KIRKLEES METROPOLITAN COUNCIL INVESTMENT & REGENERATION SERVICE

DELEGATED DECISION TO DETERMINE APPLICATIONS FOR CONSENT, AGREEMENT OR APPROVAL REQUIRED BY CONDITION

Reference No:	2026/44/91457/W
Site Address:	Bankgate Mills, Bank Gate, Slaithwaite, Huddersfield, HD7 5DL
Description:	Discharge of details reserved by conditions 3 (materials), 5 (archaeological and architectural recording), 12 (statement of works) on permission 2022/92459 for conversion of former mill to form 5 apartments including extension and alterations, demolition of outbuilding, construction of 4 open sided car port structures and associated works
Recommending Officer:	John Holmes

DECISION – Discharge of Conditions - Approved

Specification

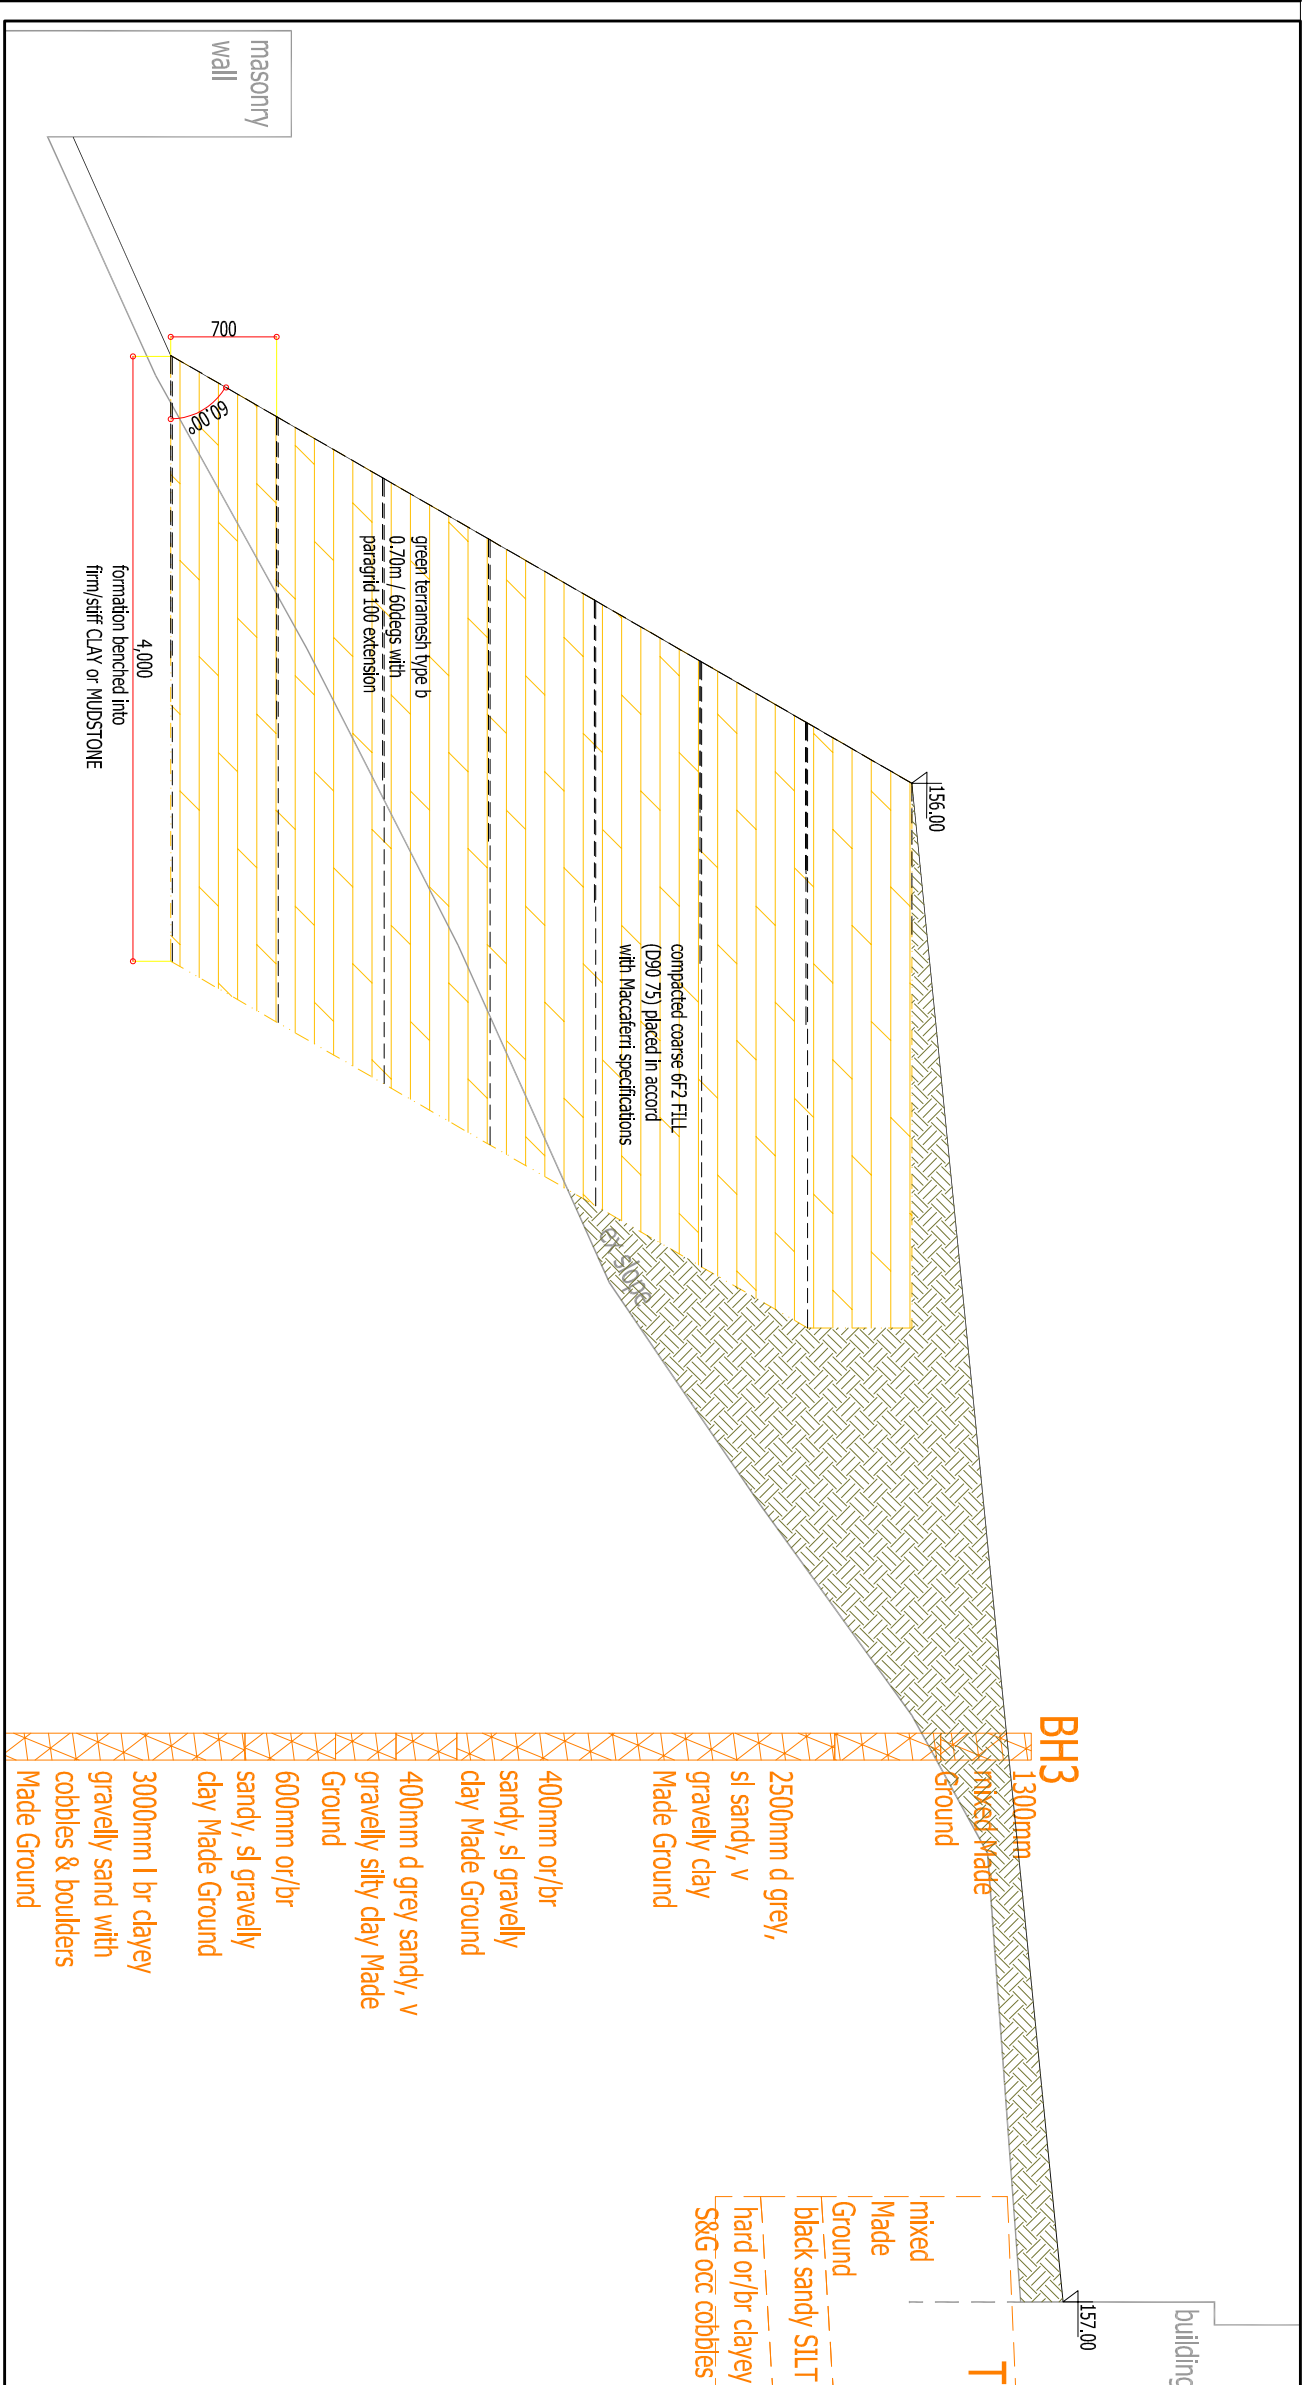
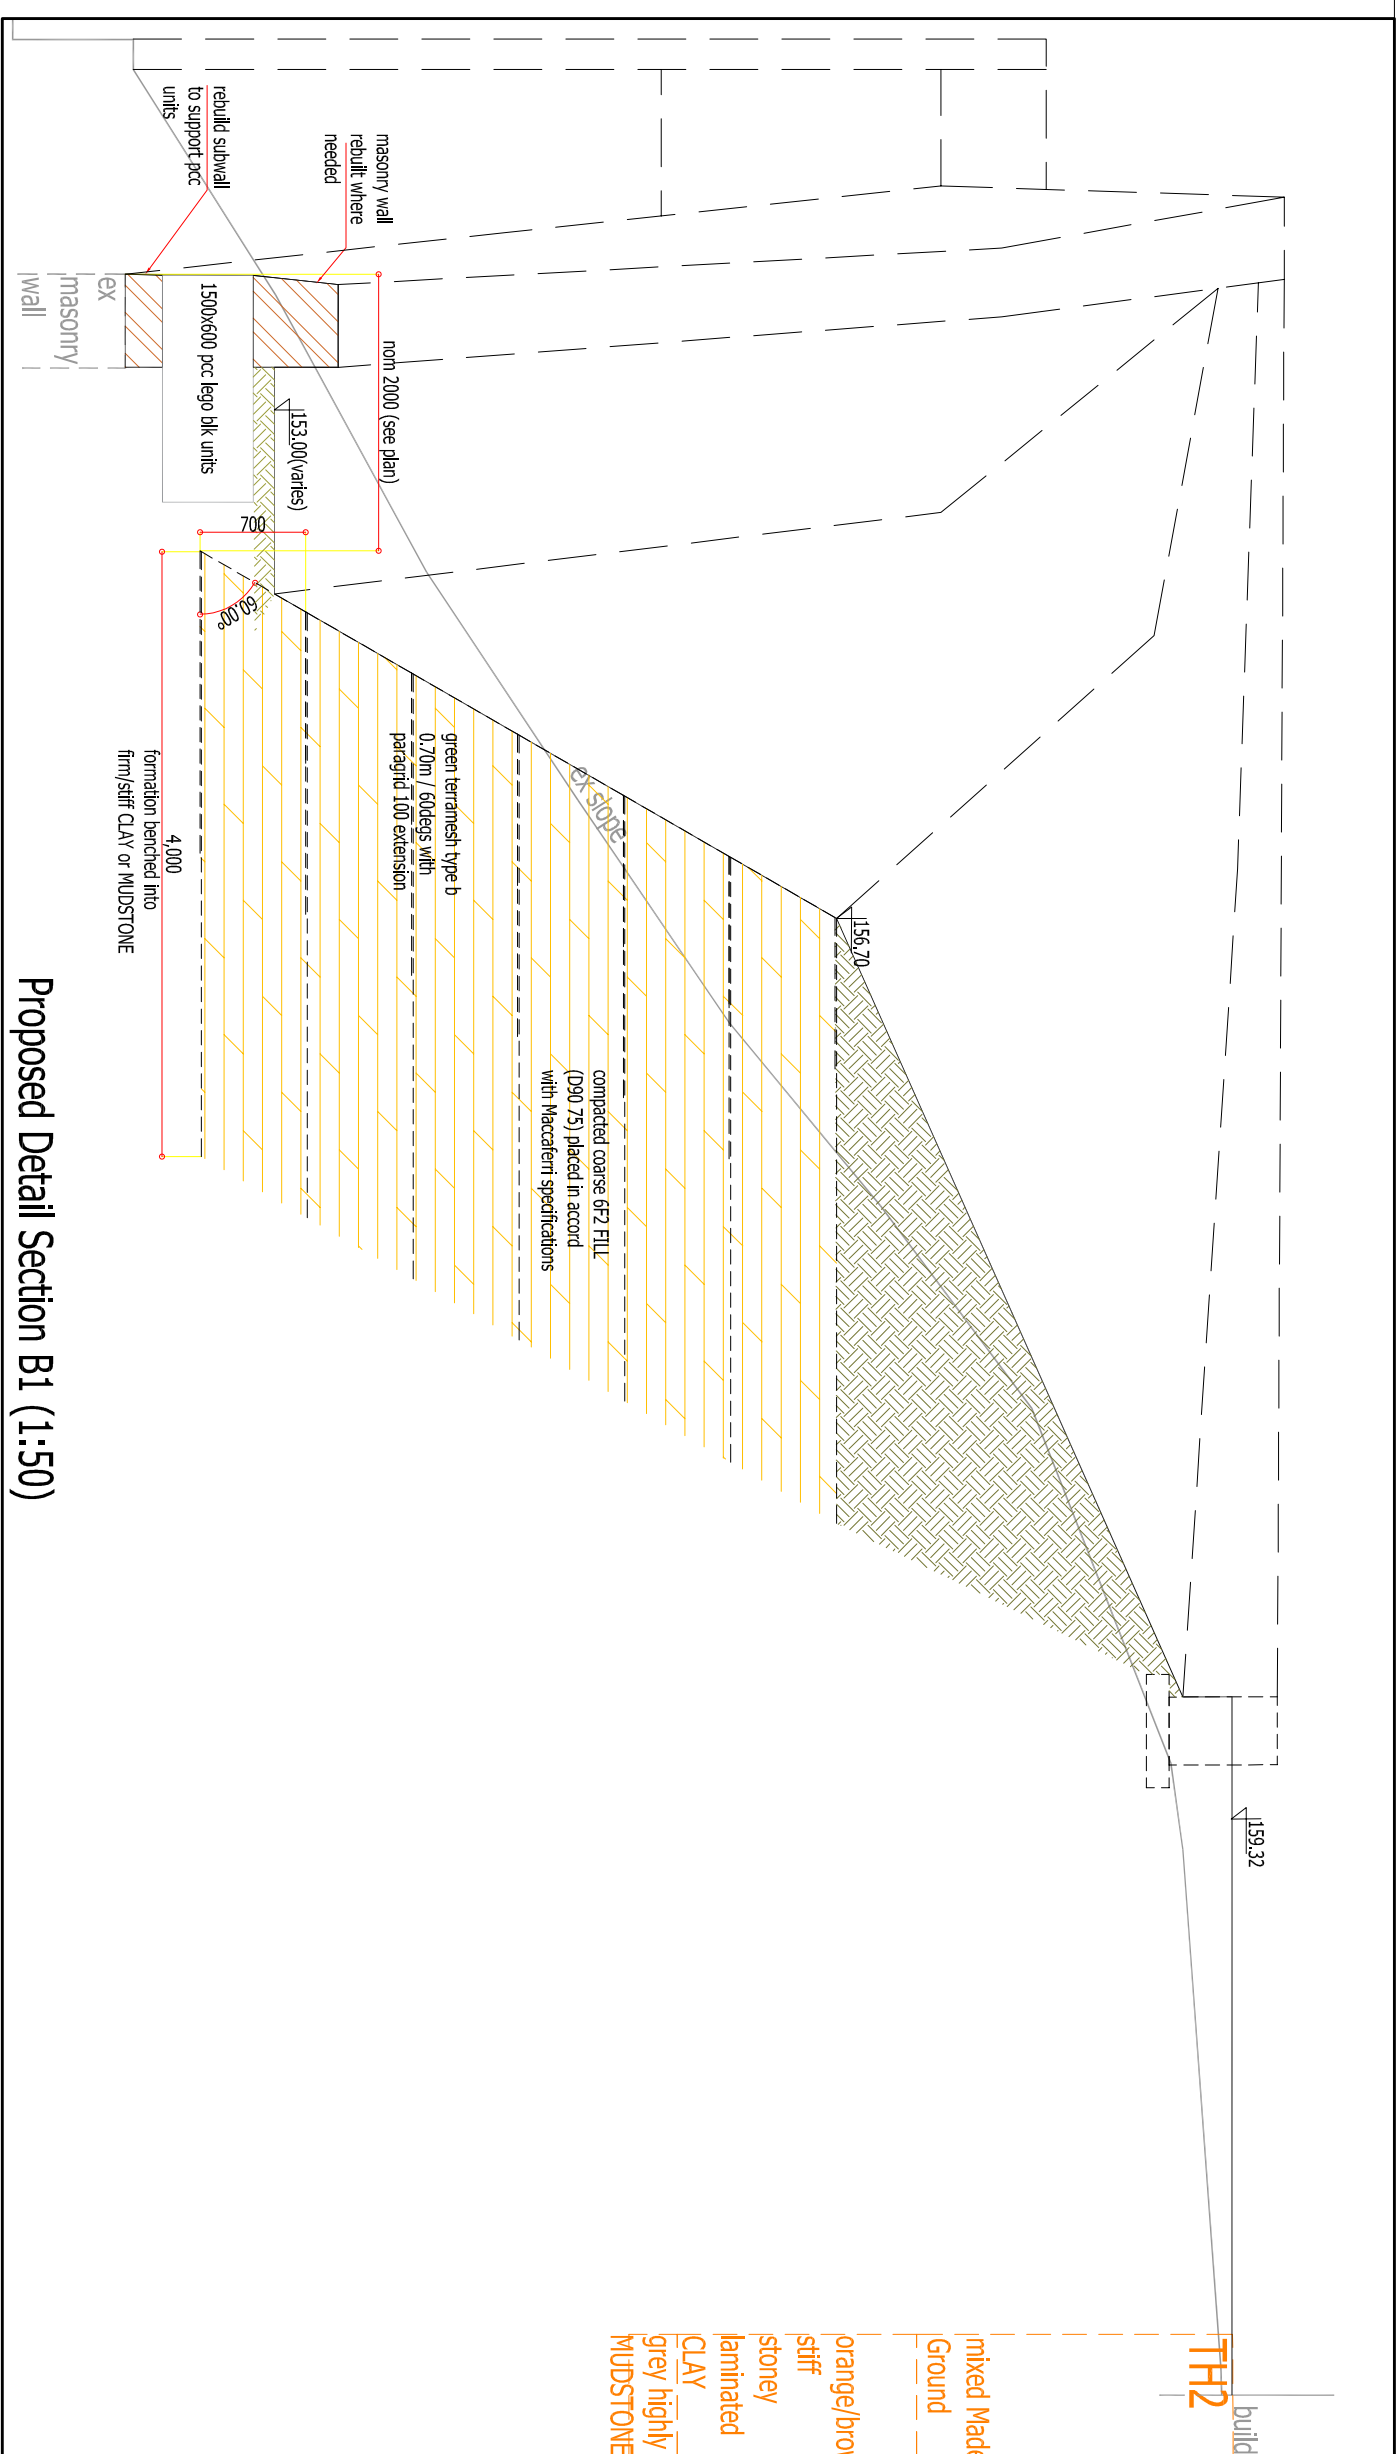
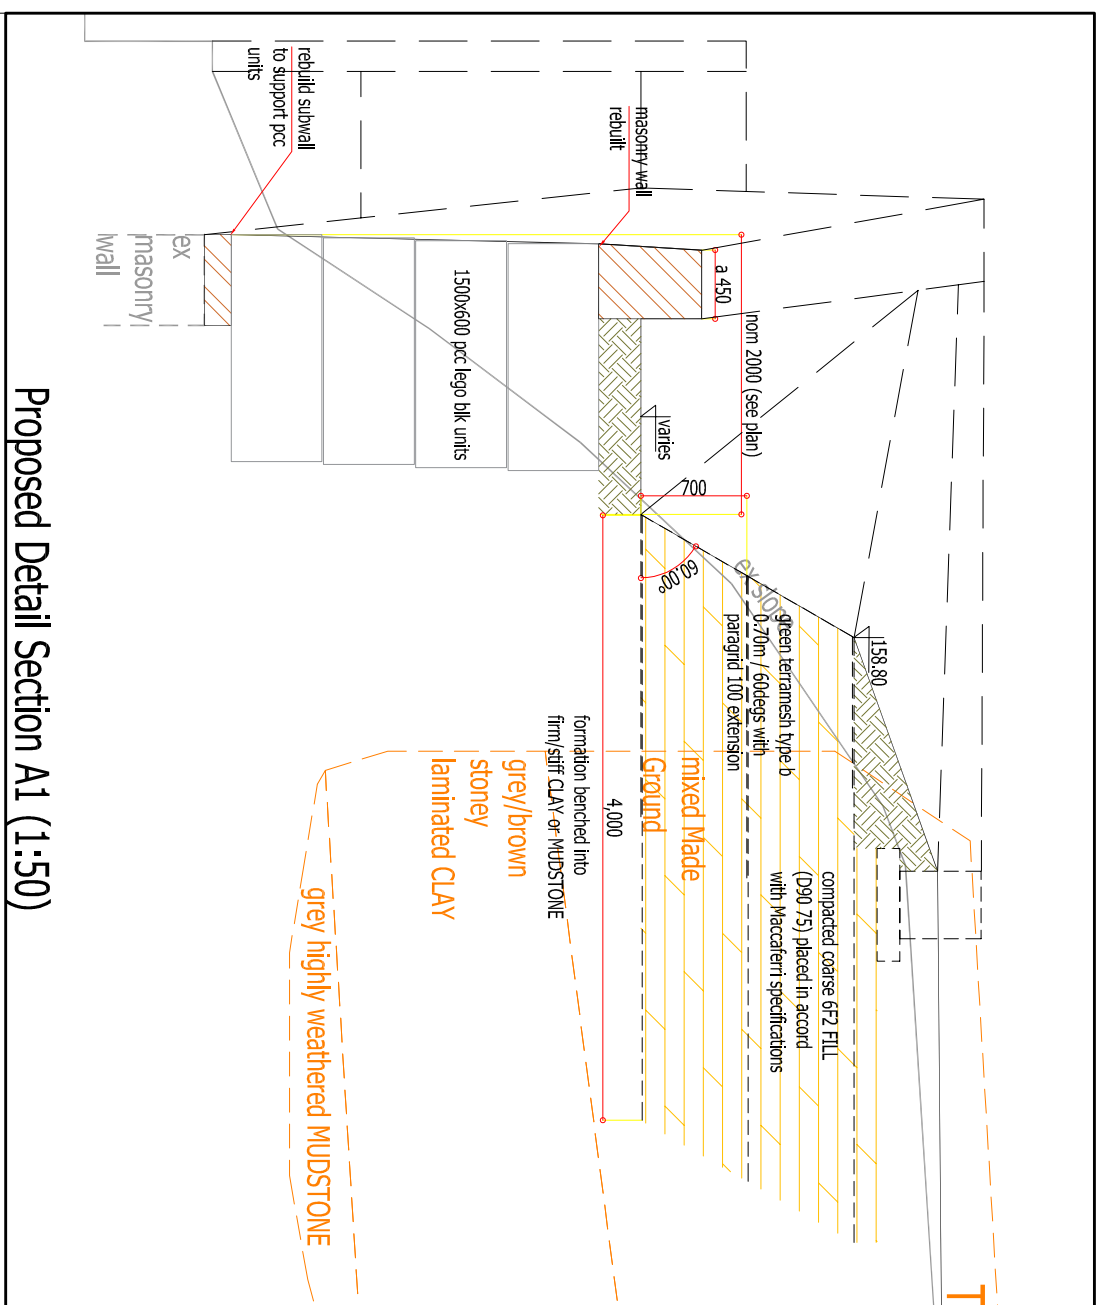
- The calculations provided to the Trust do not assess the stability of Cross Section A1 where the legato blocks are used without a geotextile reinforcement.*
- The calculations provided to the Trust do not fully explain the parameters used and the justifications for these. In line with Eurocode 7 the calculations should be accompanied by a Geotechnical Design Report which sets out Characteristic and Design Parameters used, and the load cases assessed, which has not been provided.'*

The drawings shared with the Trust and submitted alongside this application show the use of "compacted coarse 6F2 Fill (D90 75) placed in accord with Maccaferri specifications". This material should be a structural fill resistant to slippage. Associated land stability calculations seen by the Trust take this into account to determine the long term stability of the regraded slope.

Unfortunately, our observations on site of the construction works undertaken suggest that the majority of fill material used by the developer comprises of a fill with a high clay content (including fill extracted out from elsewhere on the site) which would not correspond to drawing number 250722 as submitted with the current application and as discussed directly with the Trust. We have a significant concern that the use of this material could mean that the new slope as constructed is NOT stable, and could be at risk of future collapse.

To rectify the above concern, we request that verification of the backfill material is provided in the form of PSD curves and recompacted strength testing should be provided to demonstrate that the as constructed reinforced earth wall meets the parameters used in design calculations. Should the backfill material not meet the design requirements, then a revised stability analysis should be carried out and a programme should be identified to provide for long term stability of the slope. This may require a programme to remove the loose fill on site and to import a compacted coarse fill.

The submitted scheme is considered to provide the necessary information to address condition no.12. Furthermore, it is noted that condition no.11 of the permission (2022/92459) requires that the development shall be undertaken in accordance with the works to stabilise the slope to the South West of the site as detailed upon submitted drawing 250722Rev0, the Structural Survey by TJ Booth Associates received 23/09/2025 and the Structural Calculations by TJ Booth Associates received 23/10/2025.

There remains potential for condition no.11 to be complied with, and as such it is considered that on that basis and having cognisance of the response of the Canal and Rivers Trust in relation to the submitted detail, the information submitted is sufficient to allow for the discharge of condition no.12 in this case.
